**Bersted
Parish Council**

1st February 2012

Re: BE/151/11 Shripney Caravan Park

SHRIPNEY GARDEN CARAVAN PARK, SHRIPNEY LANE, SHRIPNEY
Proposals 01 B
Nov 2011

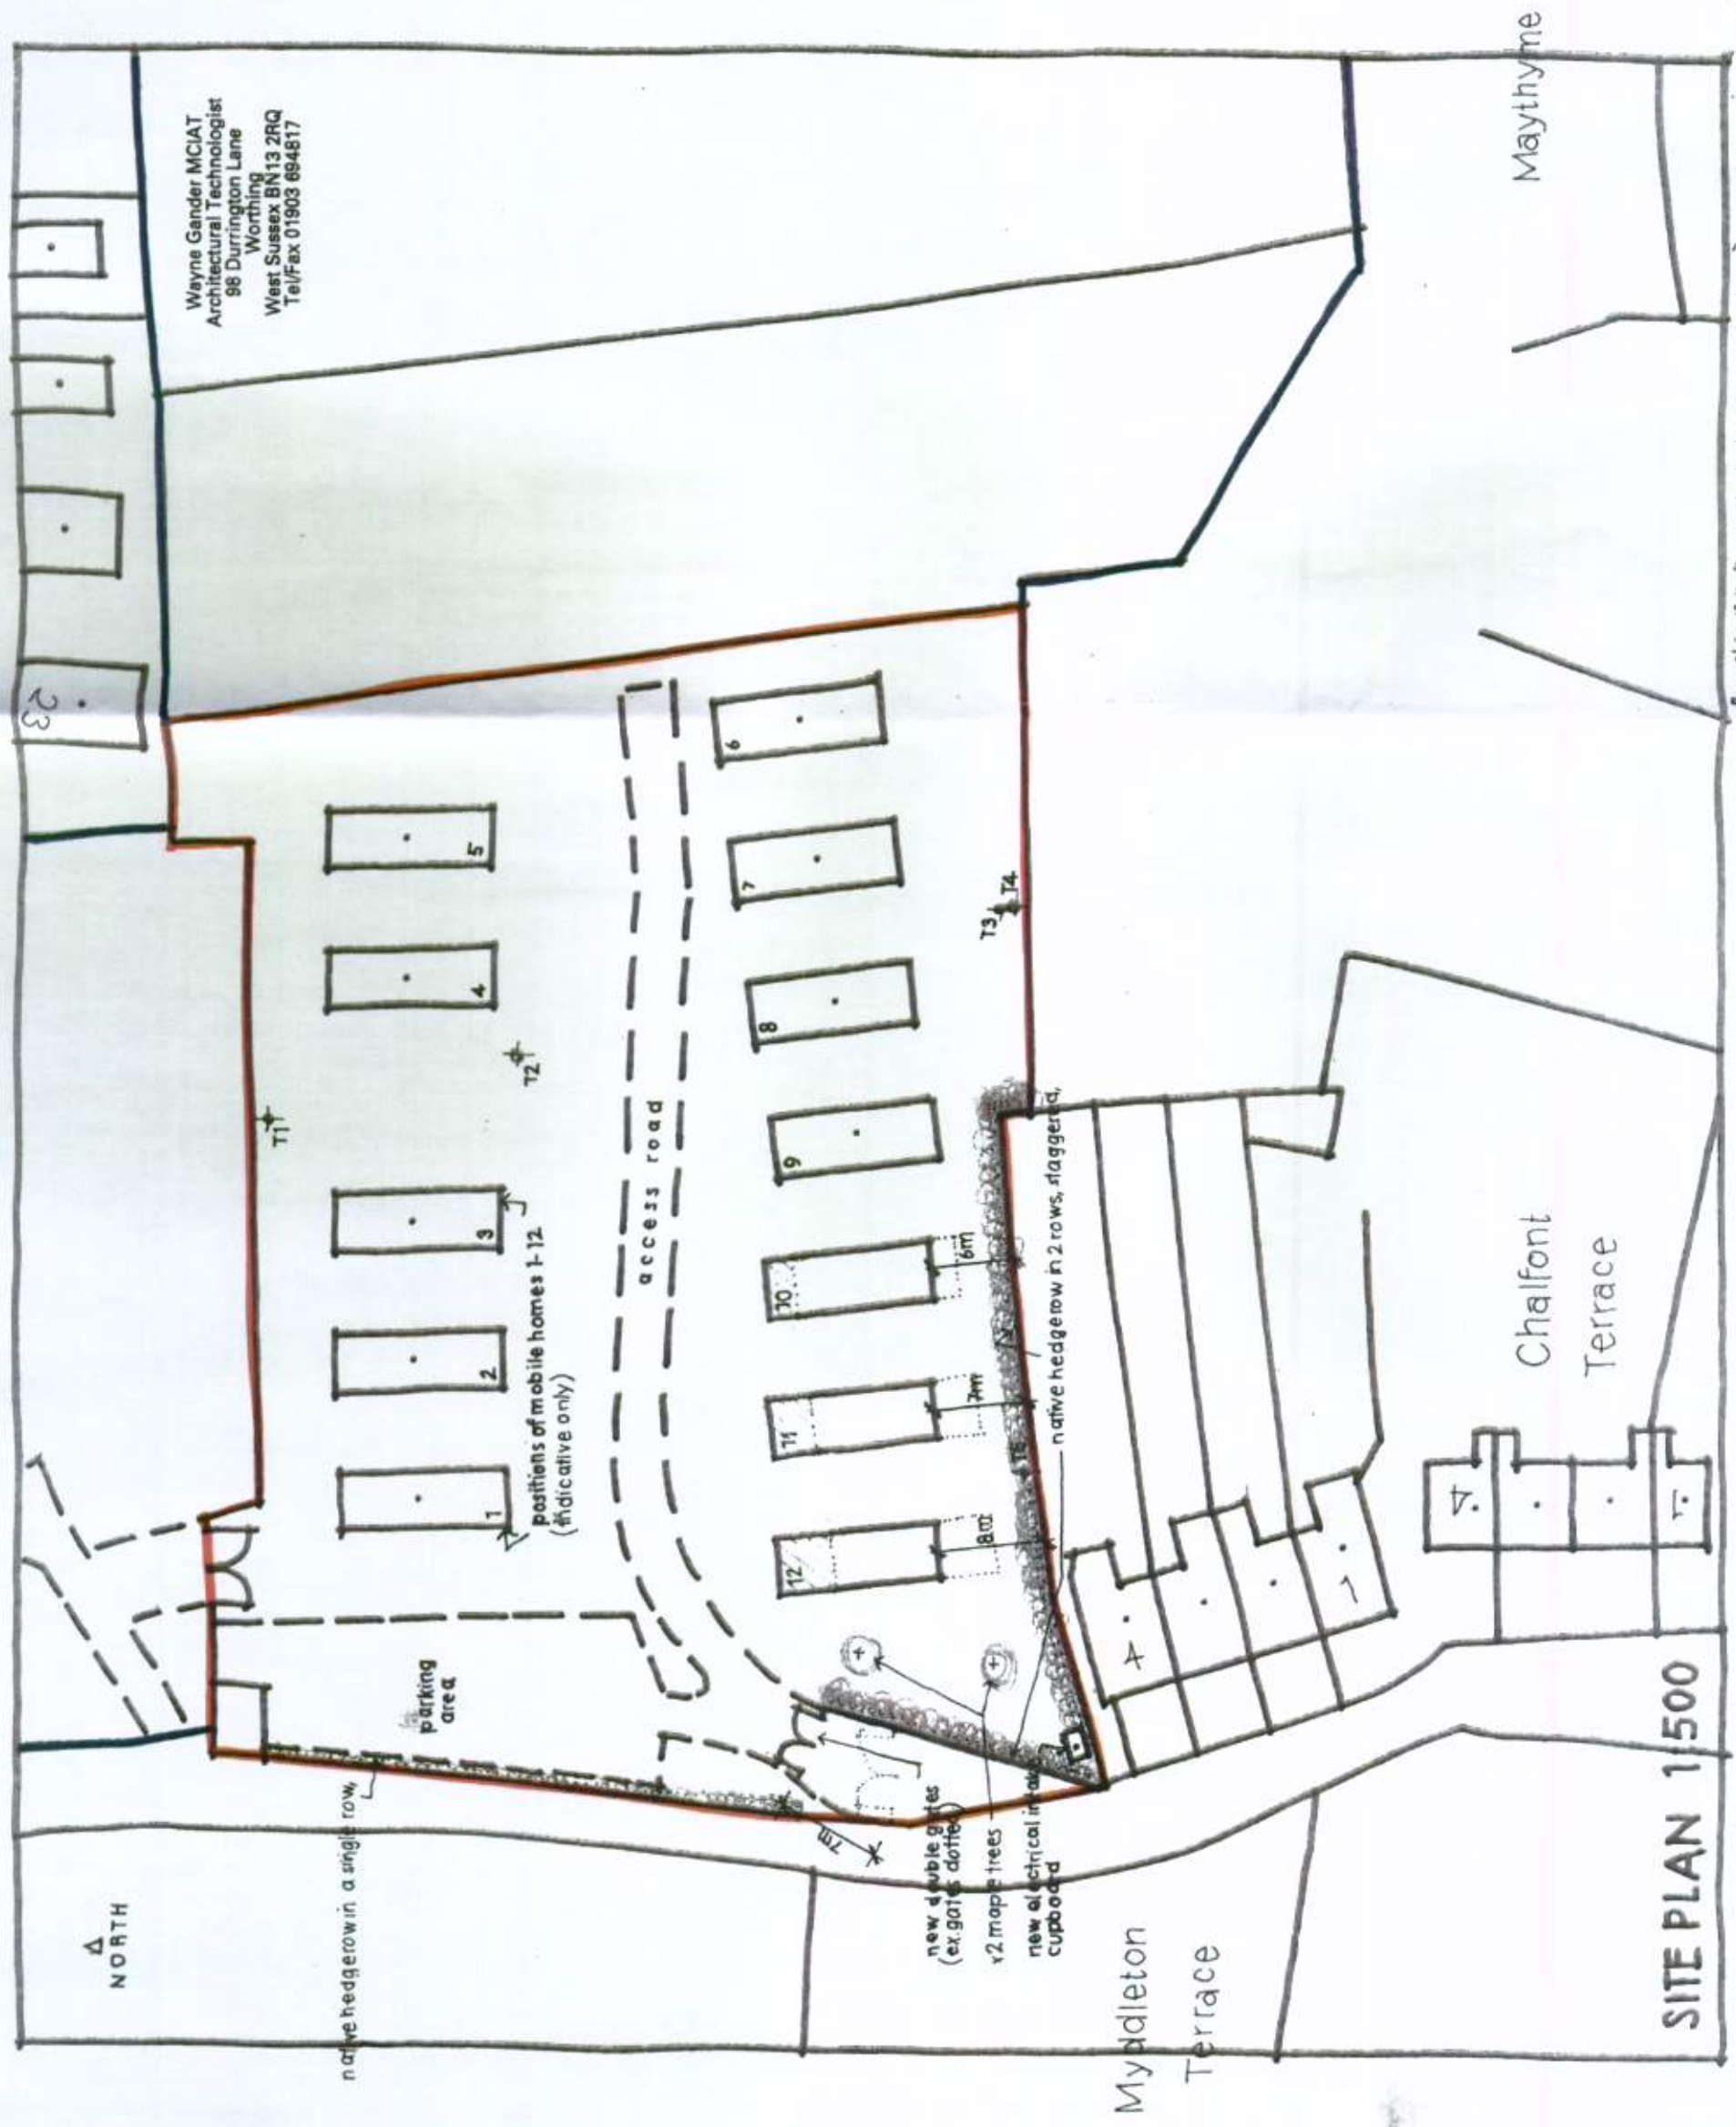
- Privacy. Mrs Jolley, the resident most directly affected, does not think the landscaping will be a good enough barrier. The landscaping is very immature at the moment and quite sparse, it is hoped that more dense, native flora could be added to screen and shelter.

- the new entrance should be for caravans only. In order to minimise engine noise and pollution all other vehicular access should be from the other entrance further away from the existing housing.

I would appreciate it if you can confirm that the existing landscaping will be increased to include native flora which does create a barrier and further thought is given to the possibility of vehicular restriction at the first entrance.
